# MDT-SF22037-R1-CDs-GEC.pdf Markup Summary

SF2237

STERLING RANCH EAST FILING NO. 2
 CONSTRUCTION PLANS
 INITIAL GRADING AND EROSION CONTROL PLAN

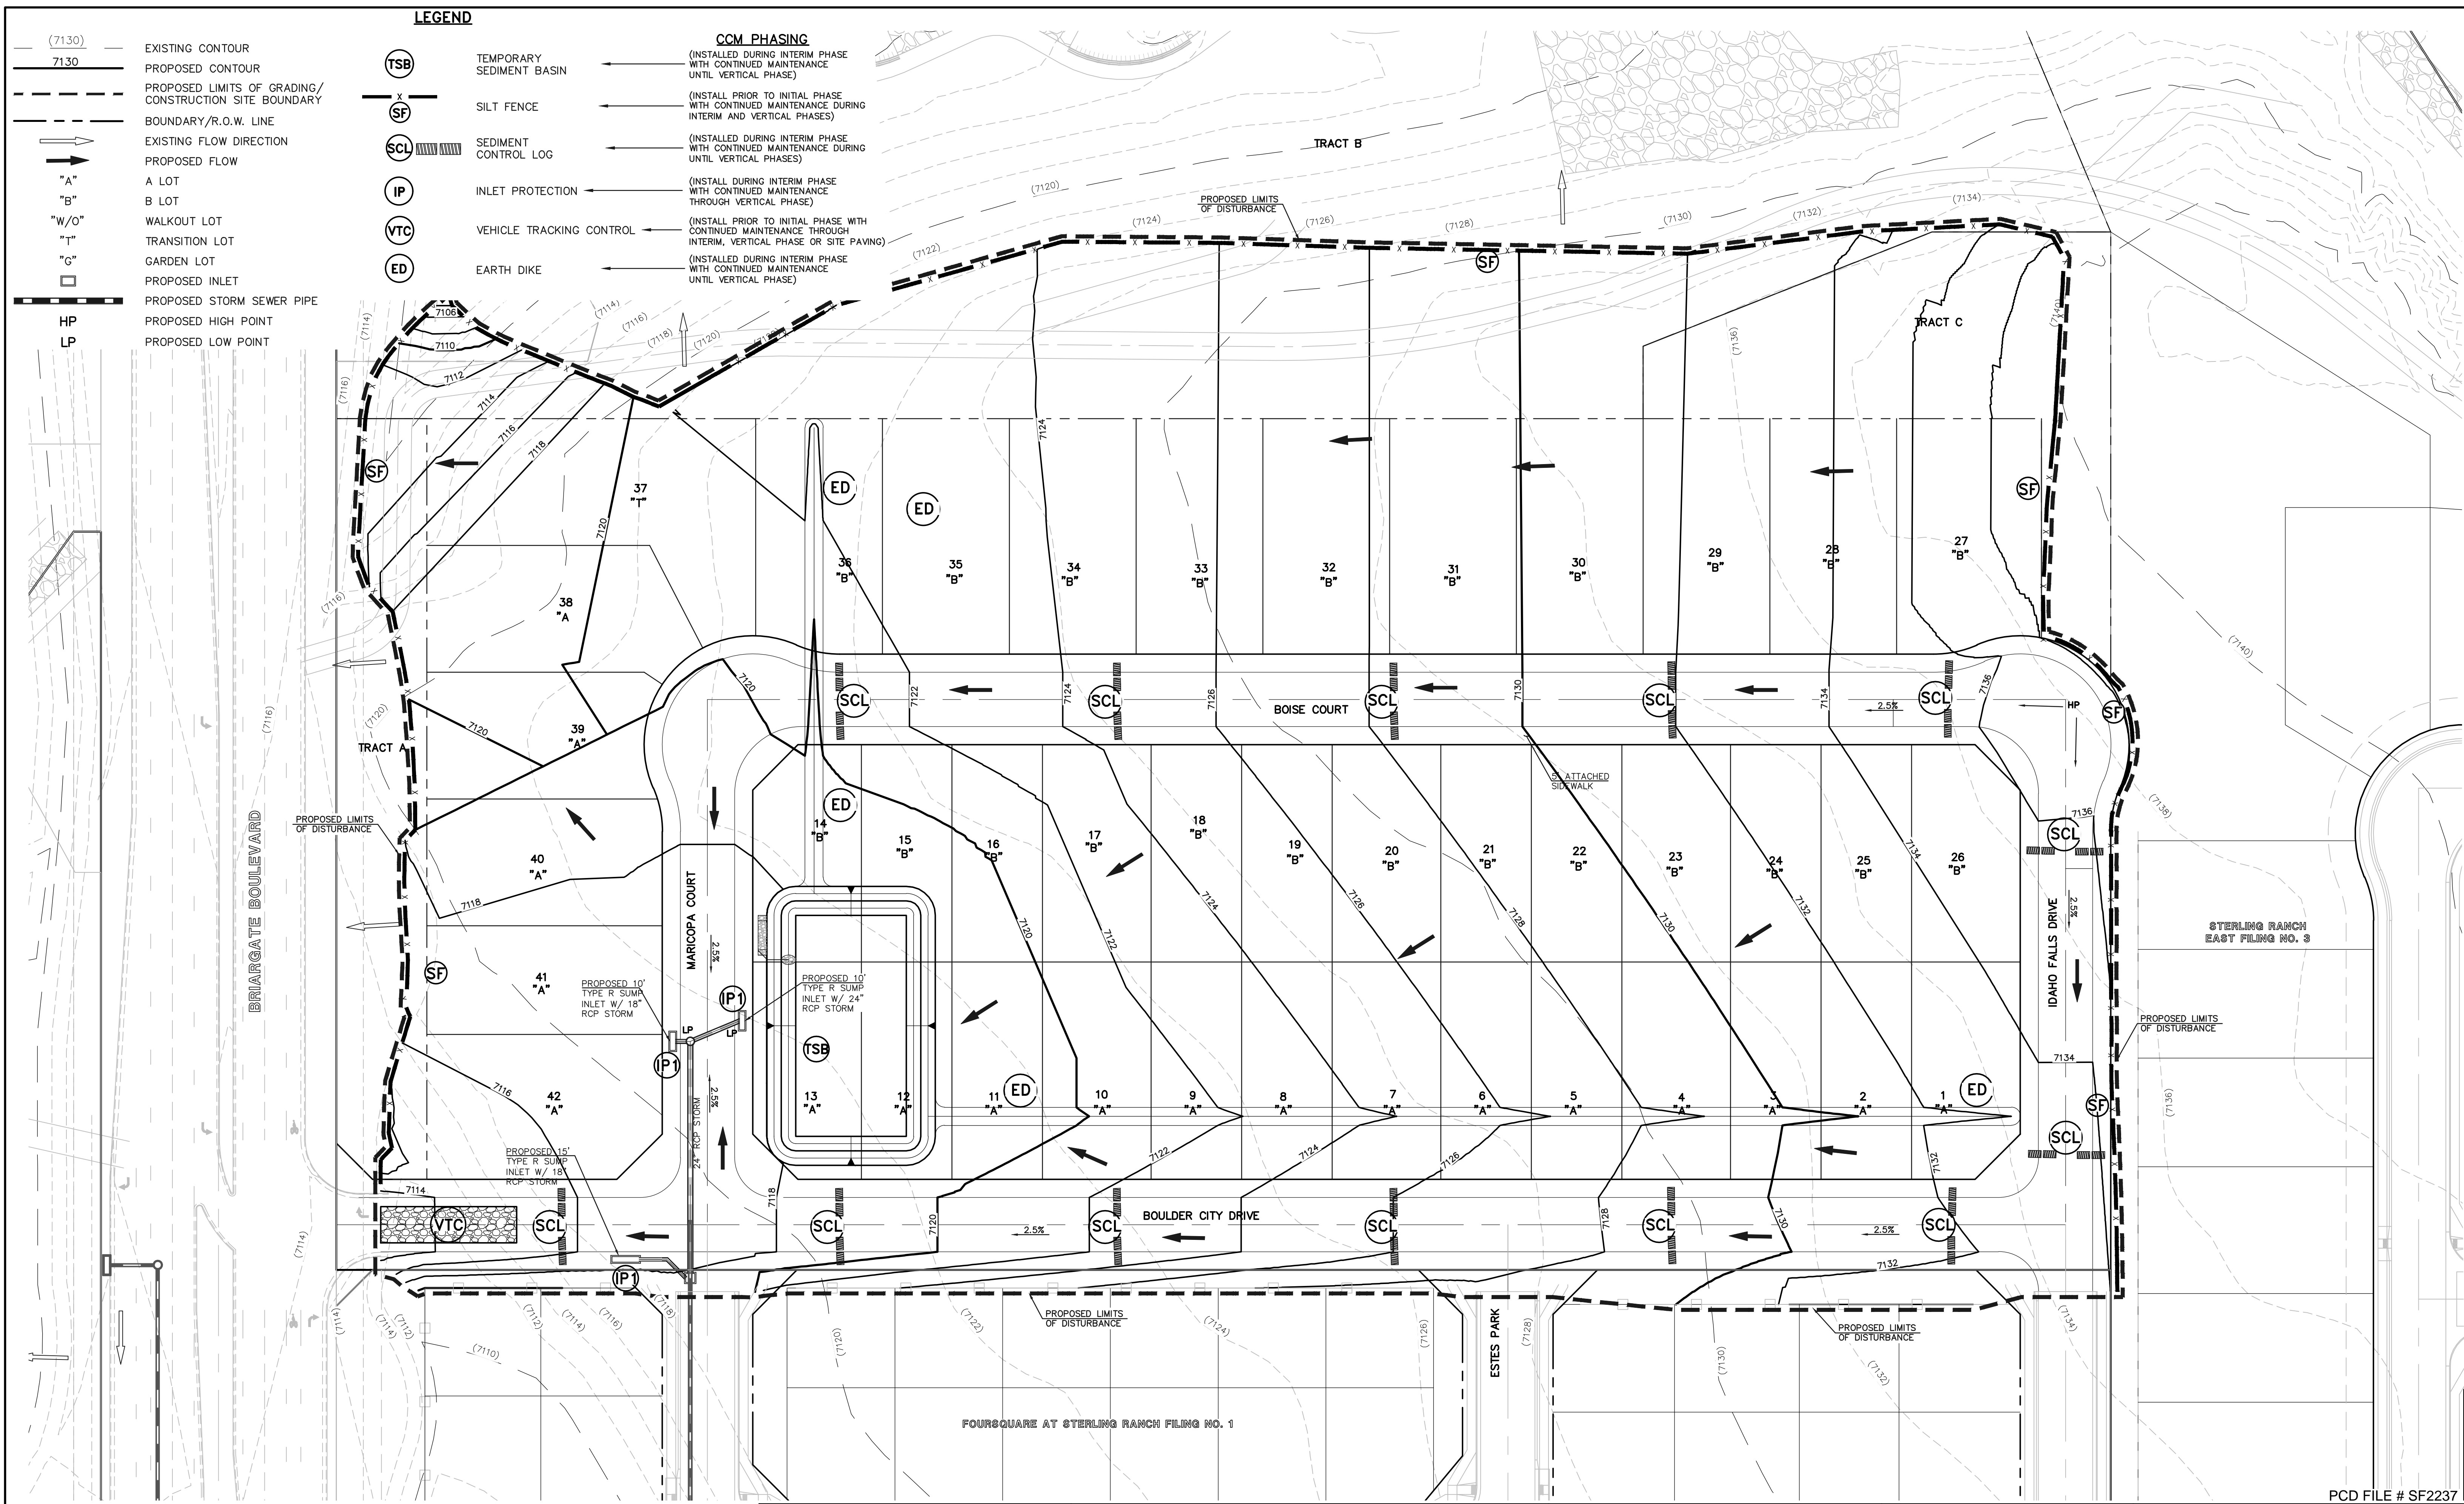
Add seeding, mulching, and straw bales to Legend and show them on the plans since they are included in the FAE Form

Show seeding, mulching, and/or ECB in this area

show location on plans.

Show location on plans. With ~11 of the total 16acres disturbed during overlot grading, a TSB is required. Also flows from the site will need to be conveyed to the TSB(s) somehow via rough cut streets and swales. Show this intial/interim condition. It might be easier on a separate sheet to show temp BMP conditions prior to utility and road installation.

STERLING RANCH EAST FILING NO. 2
CONSTRUCTION PLANS
KEY MAP WITH TYPICAL STREET SECTIONS

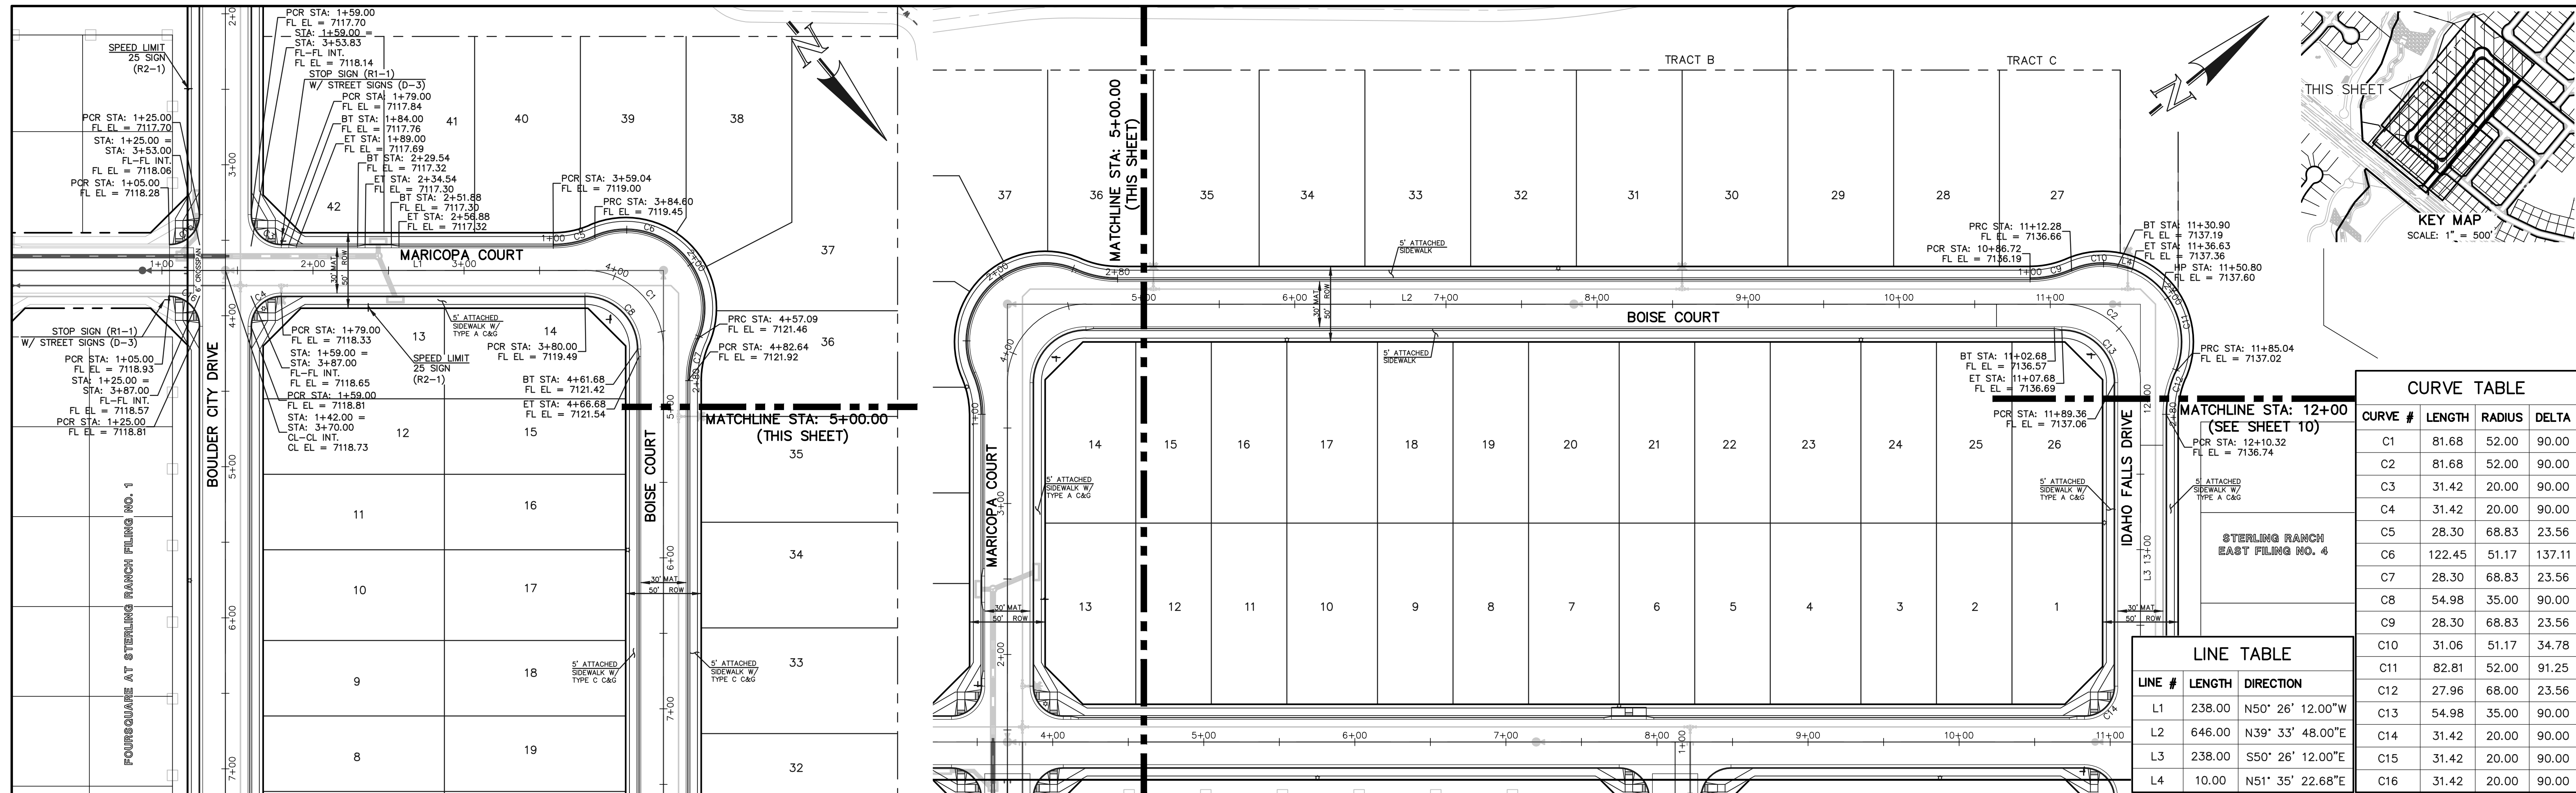
Label existing/tie-ins

LIGHT POLE OWNERSHIP AND RESPONSIBILITY:
DEVELOPER RESPONSIBLE FOR COST OF POLE DESIGN AND INSTALL
MVEA OWNS AND MAINTAINS LIGHT POLES UPON INSTALL
LOCAL DISTRICT/HOA RESPONSIBLE FOR LIGHT POLE ELECTRICITY COSTS

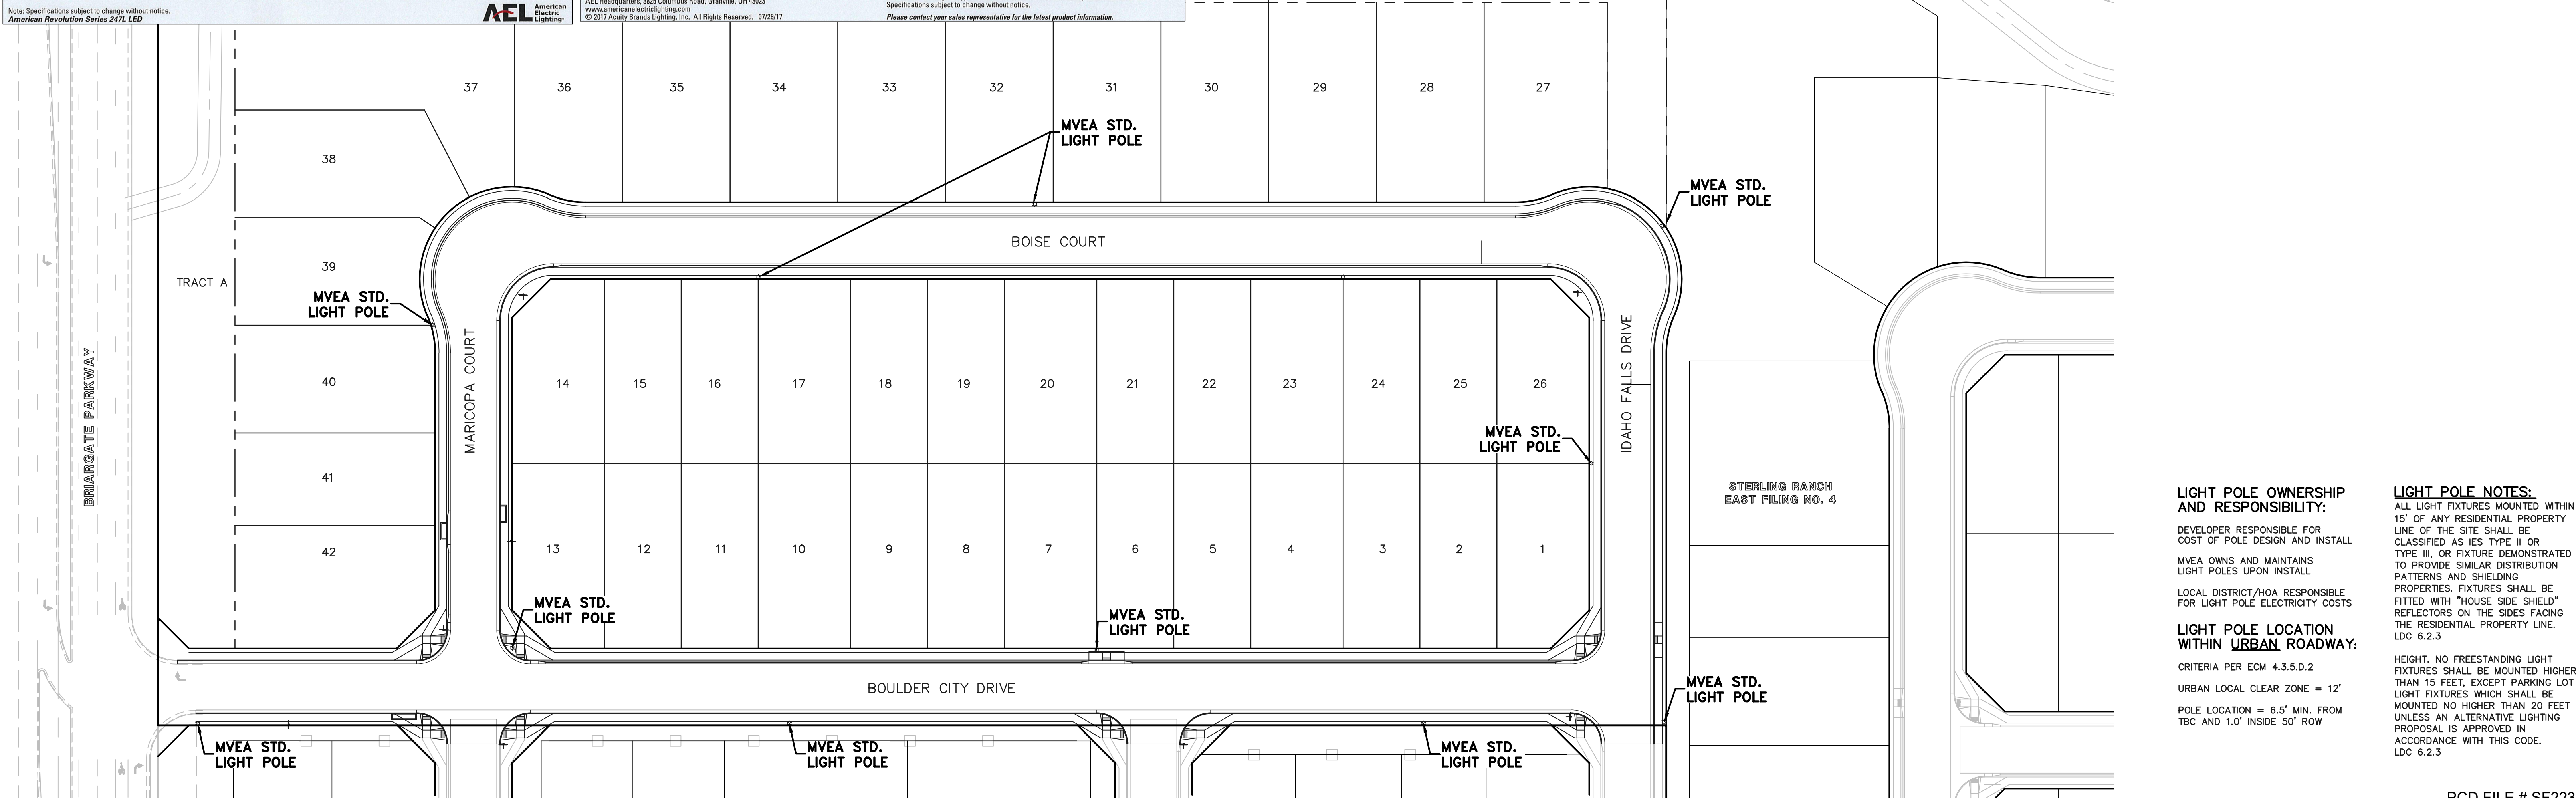
Street light and/or signage should be provided here so northbound traffic is less likely to drive off road

PUBLIC 18" RCP STORM - 'LATERAL A2'

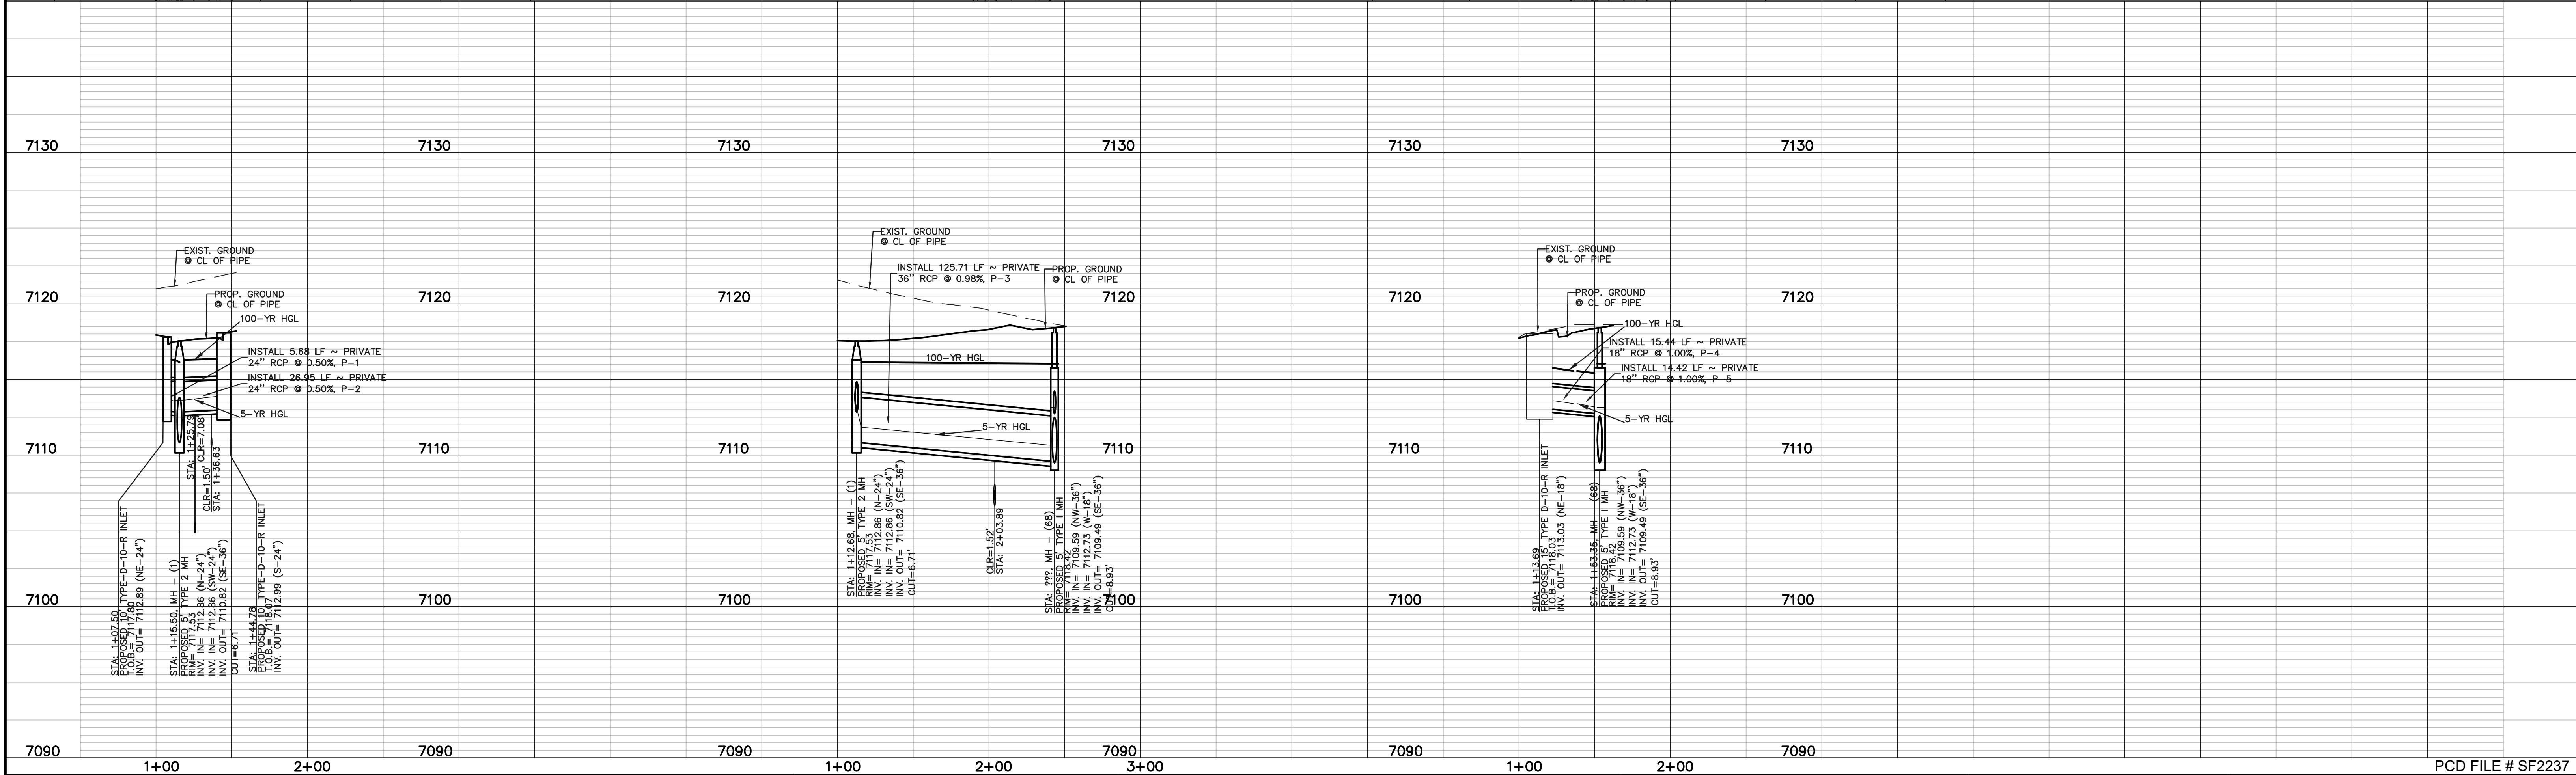
Review of the storm system will be completed with next submittal after drainage flows and storm system has been revised.

HGL too high
